From: Shaban, Sundas
Sent: 25 April 2022 15:19
To: _planningadvice
Subject: FW: H09-0186-22 - 19 North Parade

From: Shaban, Sundas
Sent: 25 April 2022 15:18
To: 'info@status-design.co.uk' <info@status-design.co.uk>
Cc: Fidler, Richard <rfidler@sholland.gov.uk>
Subject: H09-0186-22 - 19 North Parade

I can confirm condition 3 should read s follows:

C - ALTS - 10.2.22
B - INF-ADDED - 27.1.22
A - ALTS - 22.12.21

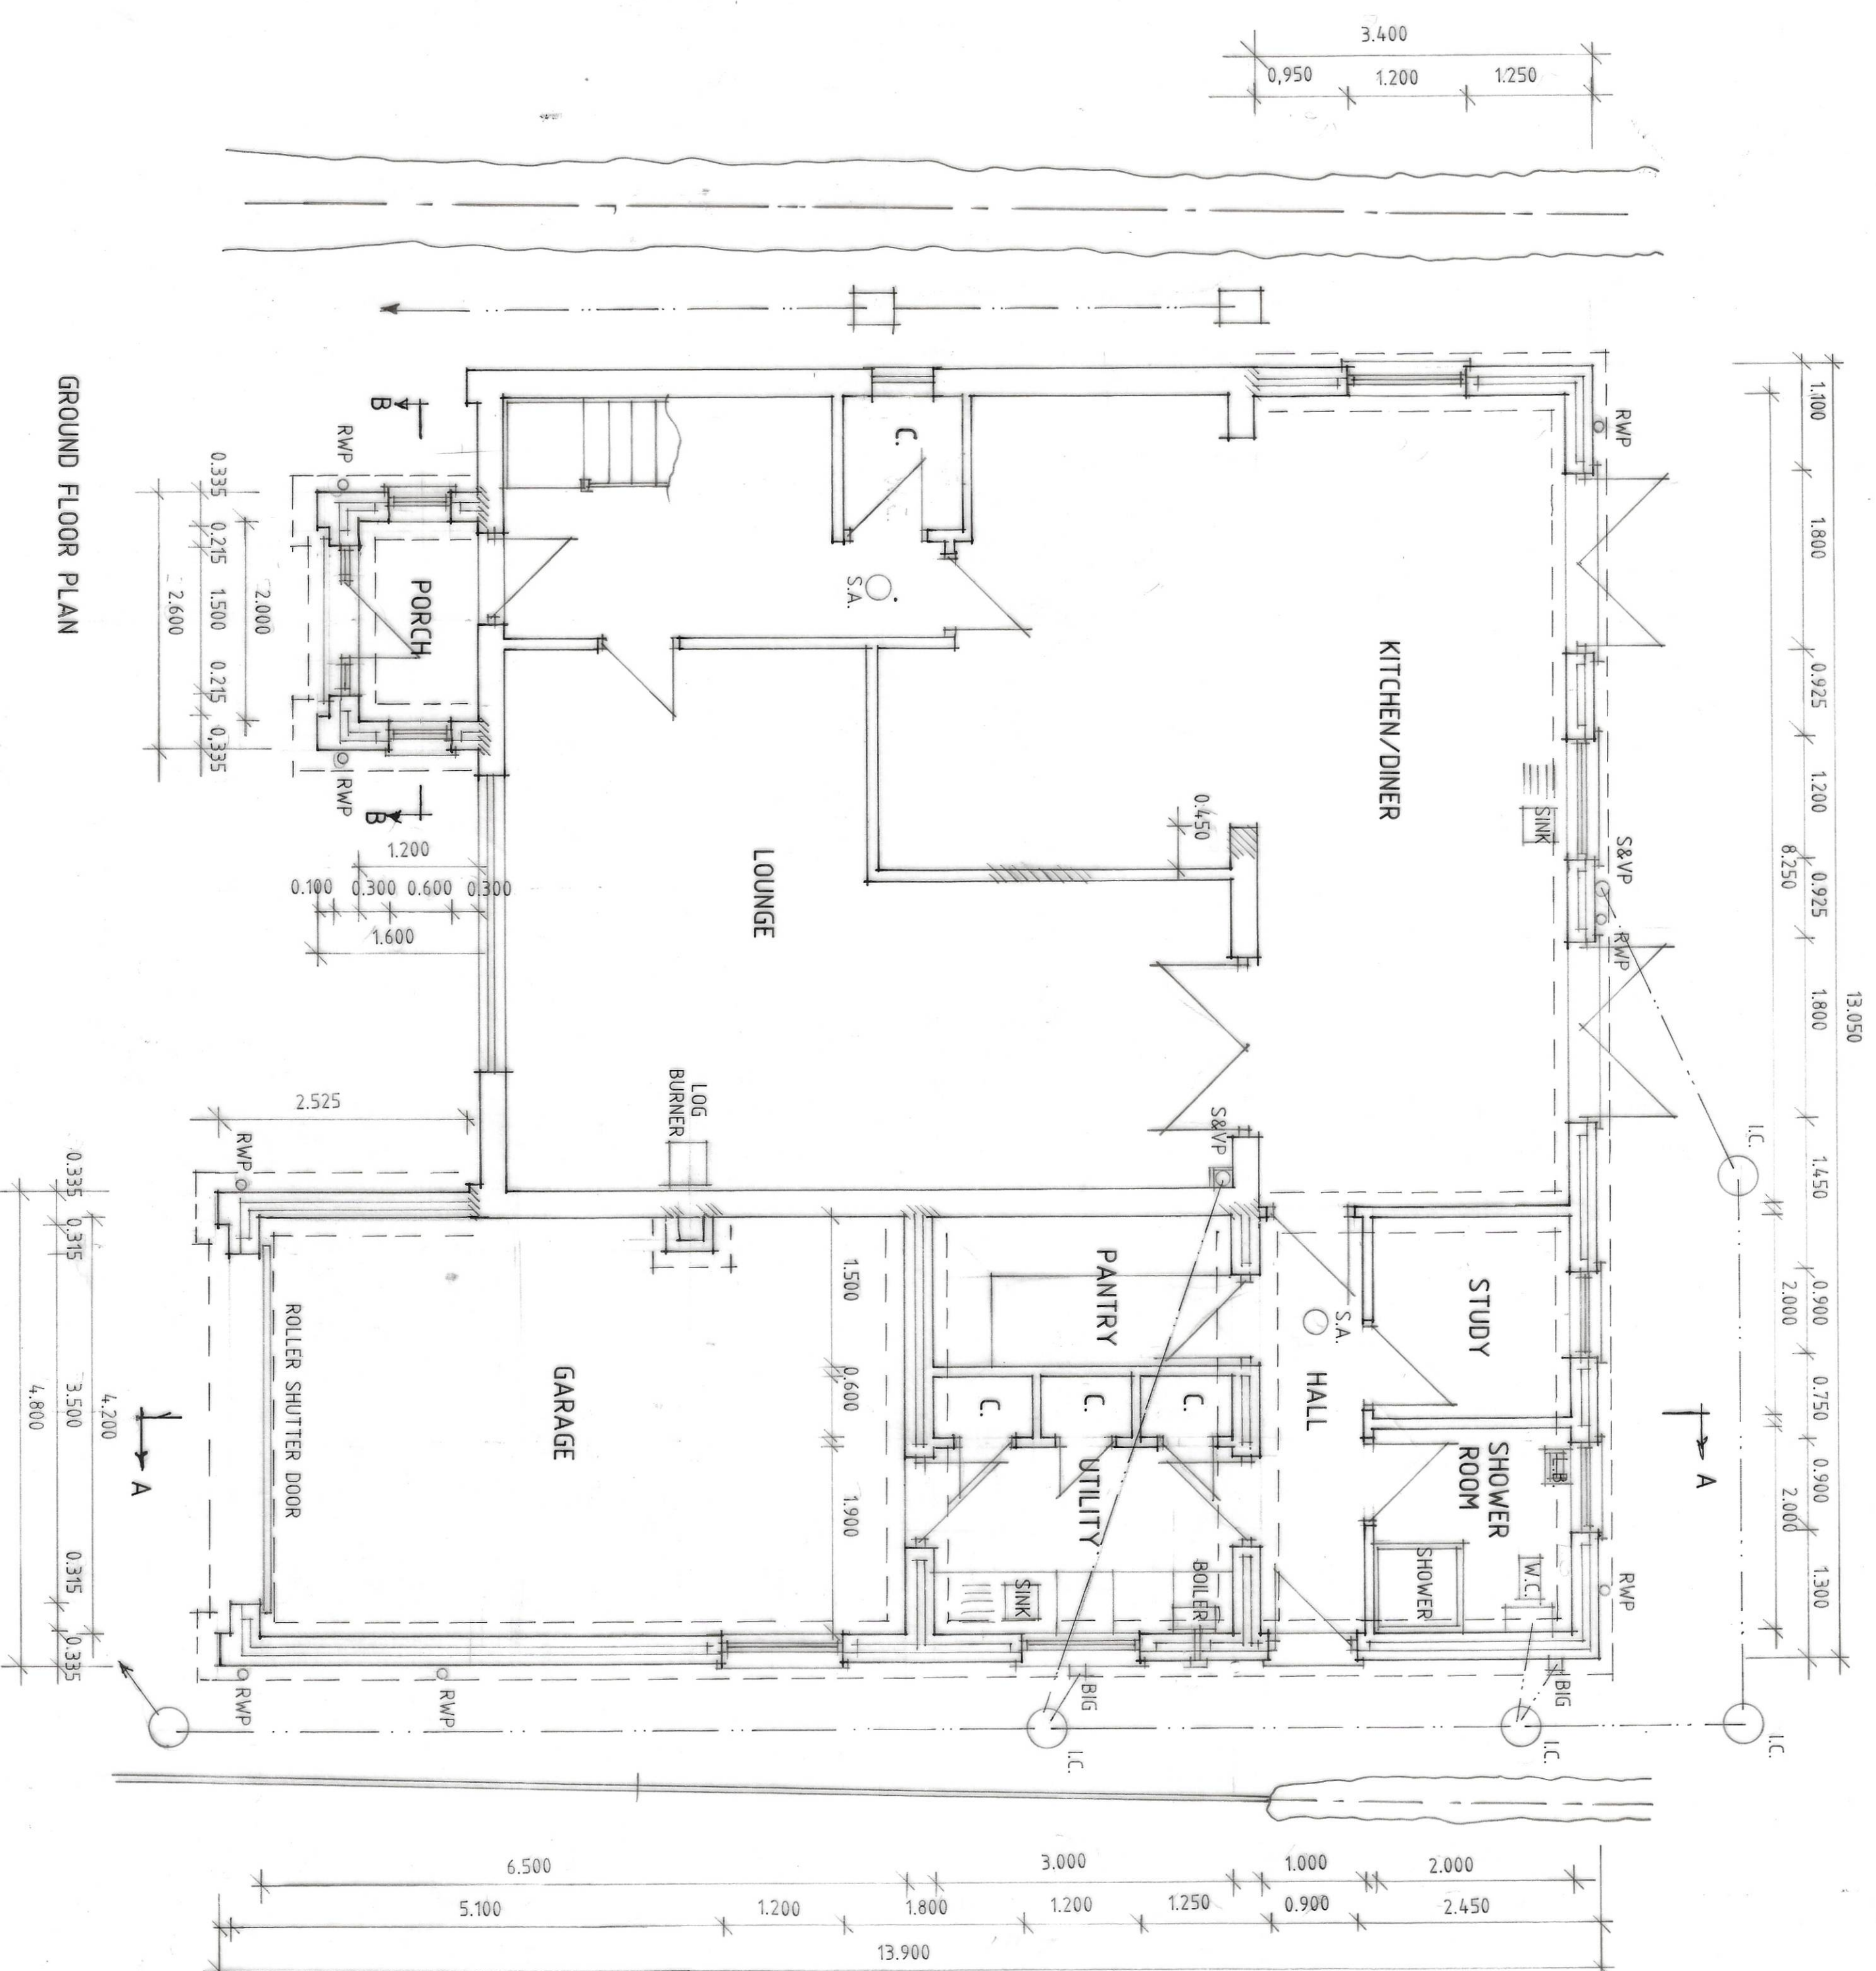
I understand there has been some misinterpretation with the submitted details of the above application and one of the conditions does not reflect what has been applied for.

Firstly I'd like to apologise for misreading the fact the entire property is proposed to be rendered.

'The external walls of the extensions and the existing dwelling shall be rendered and painted off white and all other external materials shall match as closely as possible those of the principal existing building on the site'.
